20 December 2010

Our Ref: C10/7304 & 2008/0189V2

RE: Part 3A Major Project Application MP 10_0104 – Exhibition of Circular Quay Public Domain Upgrade Works, Circular Quay/The Rocks

PRINCIPLES

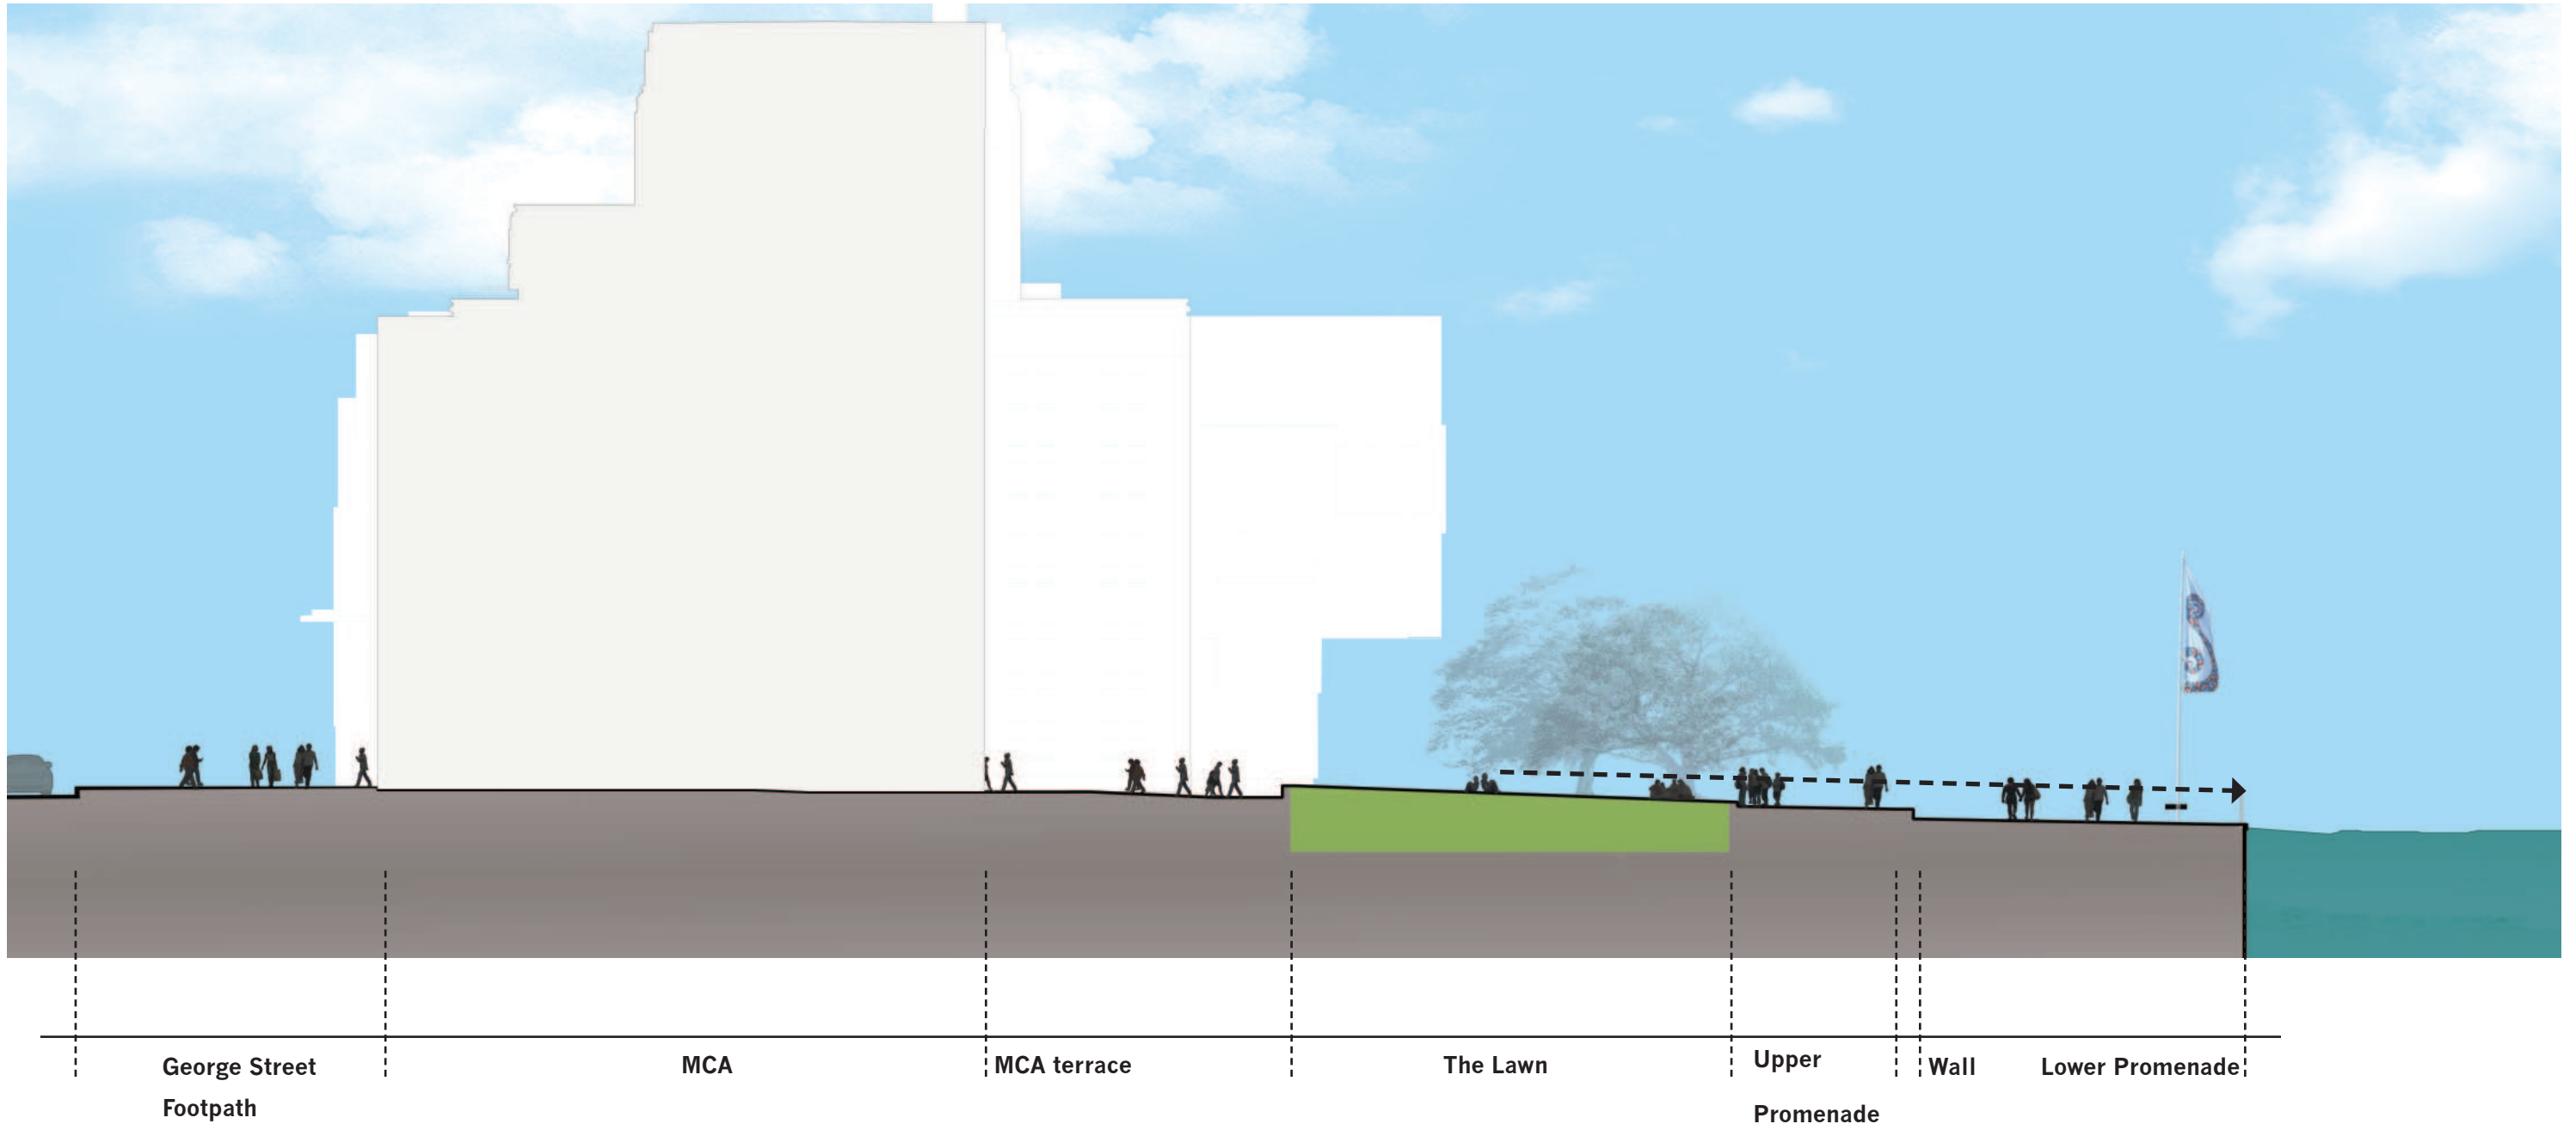
Sydney Ports is of the opinion that the potential navigation impacts on safe shipping movements proposed lighting has not been addressed as previously requested by Sydney Ports. Sydney Ports requests that a condition be imposed, if approved, that any proposed lighting needs to be downward facing or not directed towards the water/OPT to ensure no horizontal light spill occurs, which could impact on shipping navigation and safety.
